Harnett County Environmental Health

EXISTING SYSTEM APPROVAL

Property Location/Address: 45 WYNDHAM PLACE FUQUAY-VARINA, NC 27526-0000

Proposed Property Improvement: In Ground Pool Addition with Decking

Property Layout

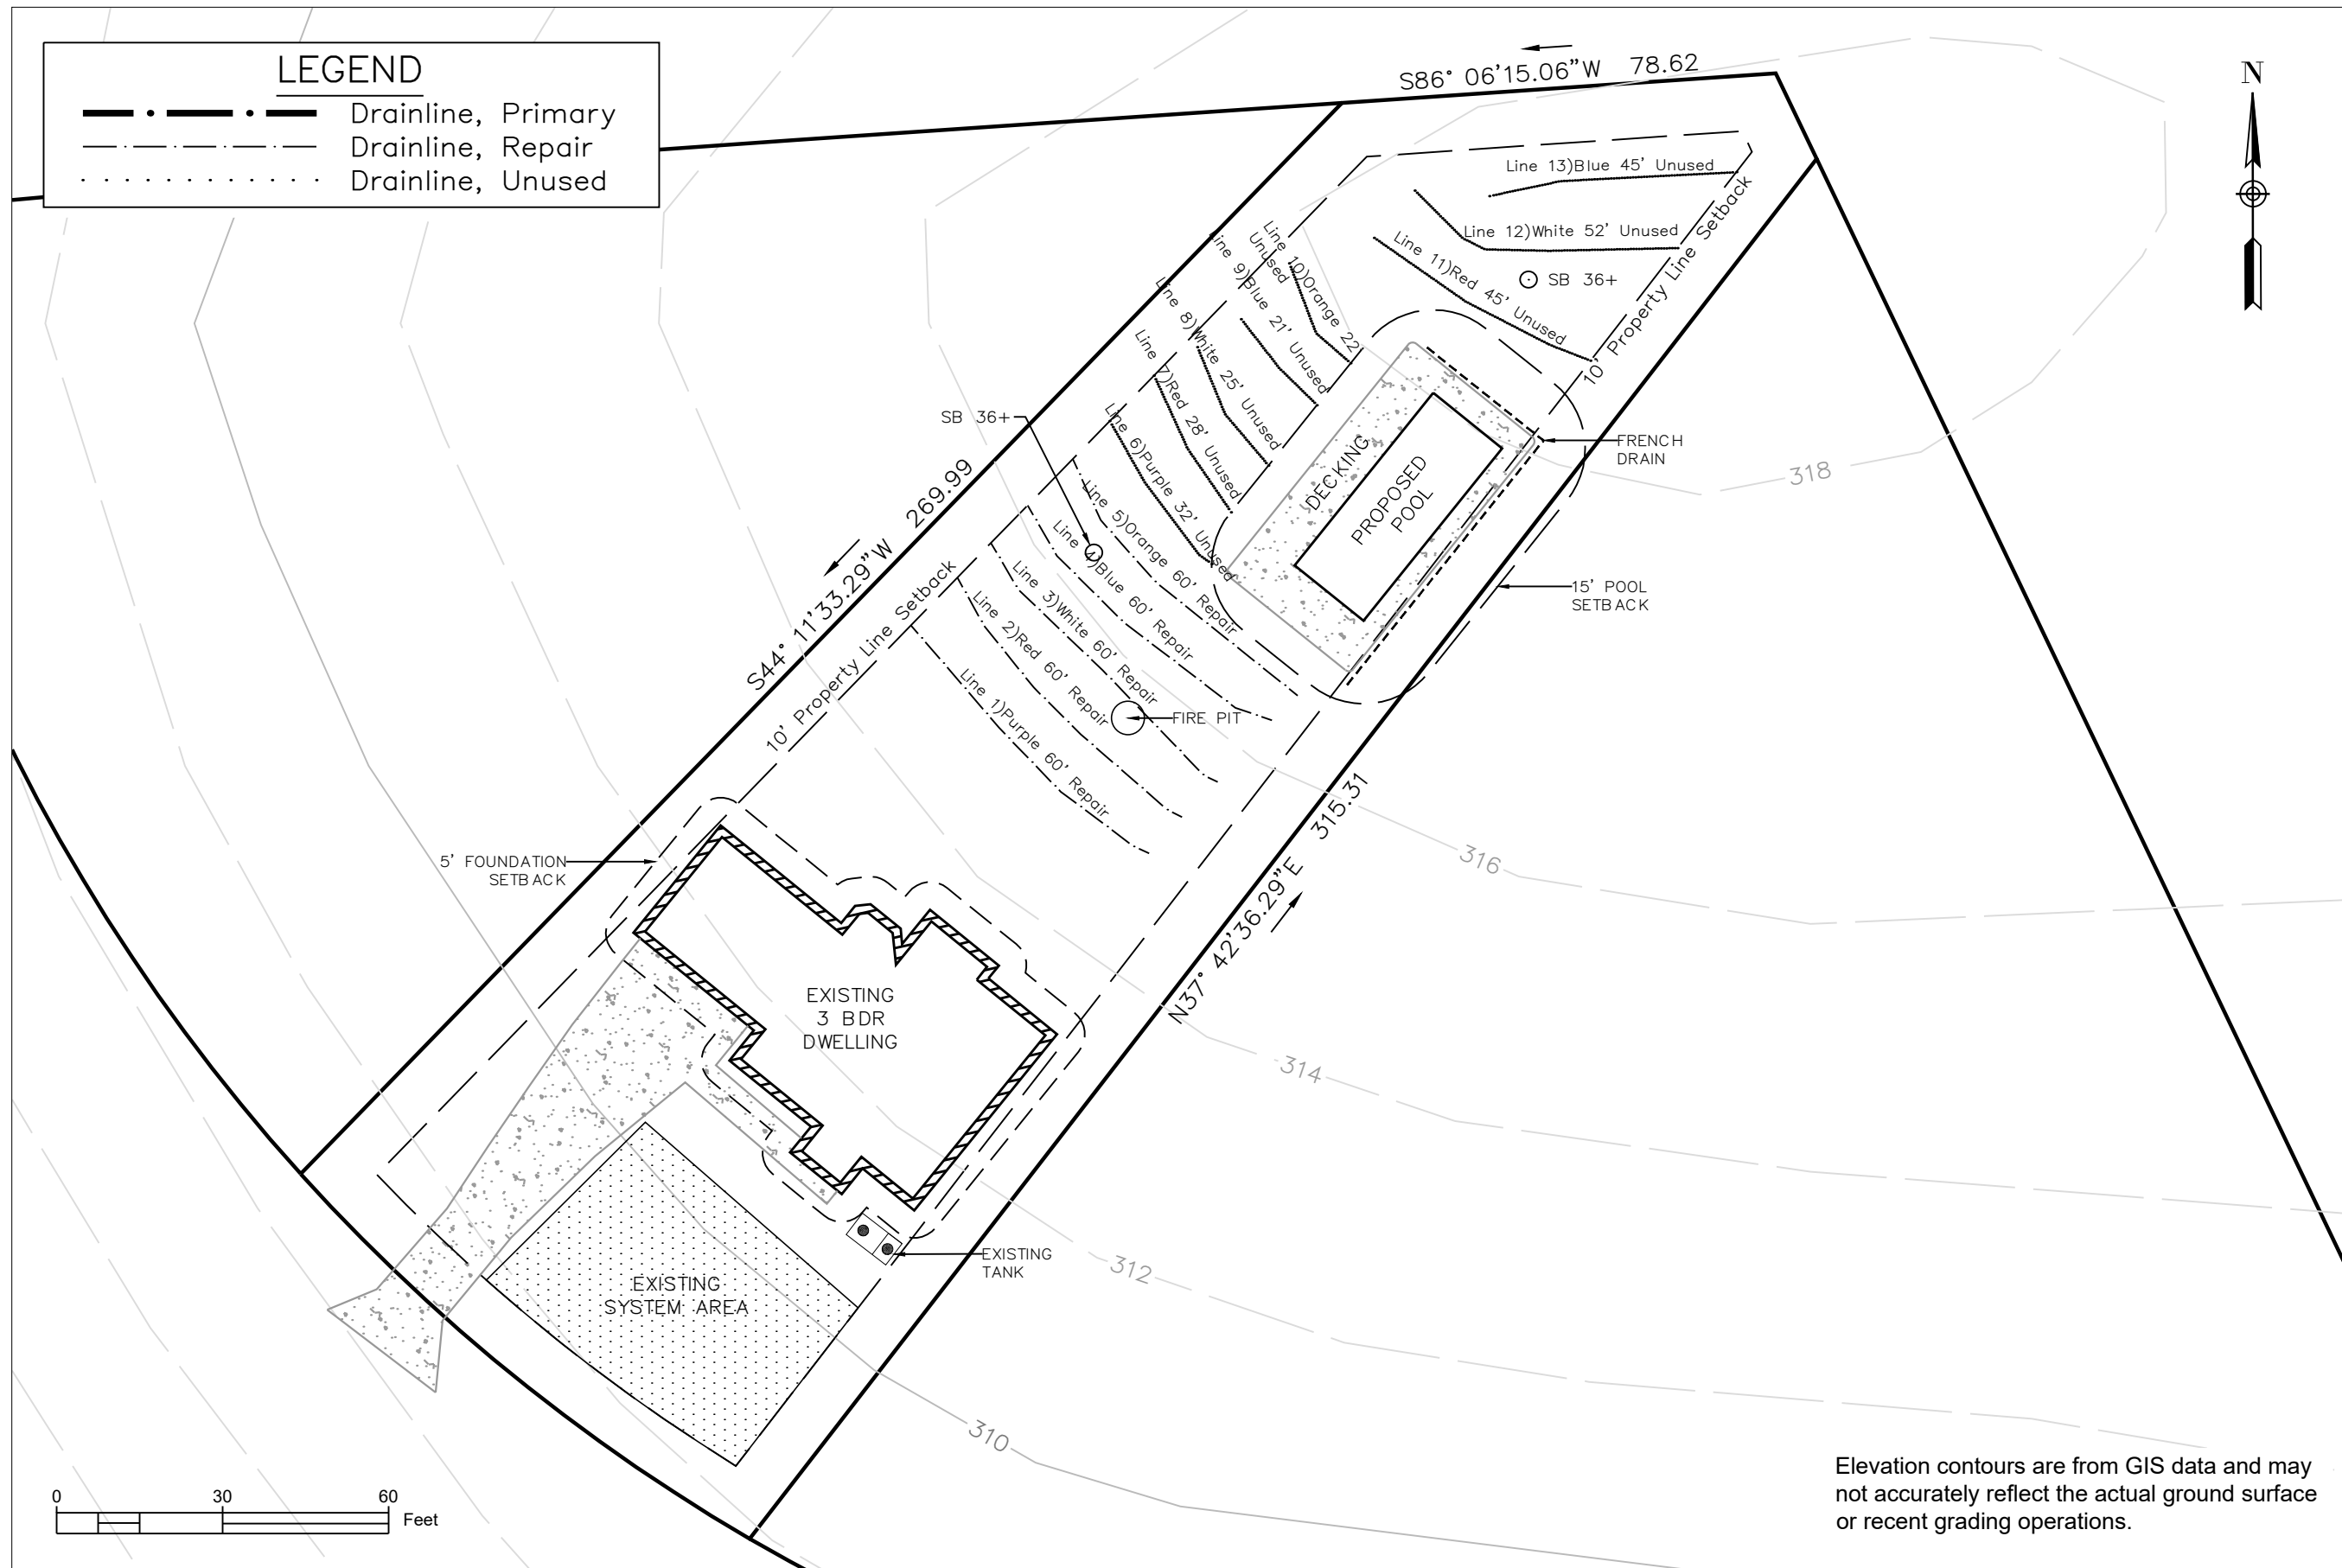
Approval Conditions: The Decking around the pool may not exceed more than 10' feet on any side of pool.

The Repair area needs to stay 15' away from in ground pool and 5' from decking foundation. Fire pit to be removed when repair is needed.
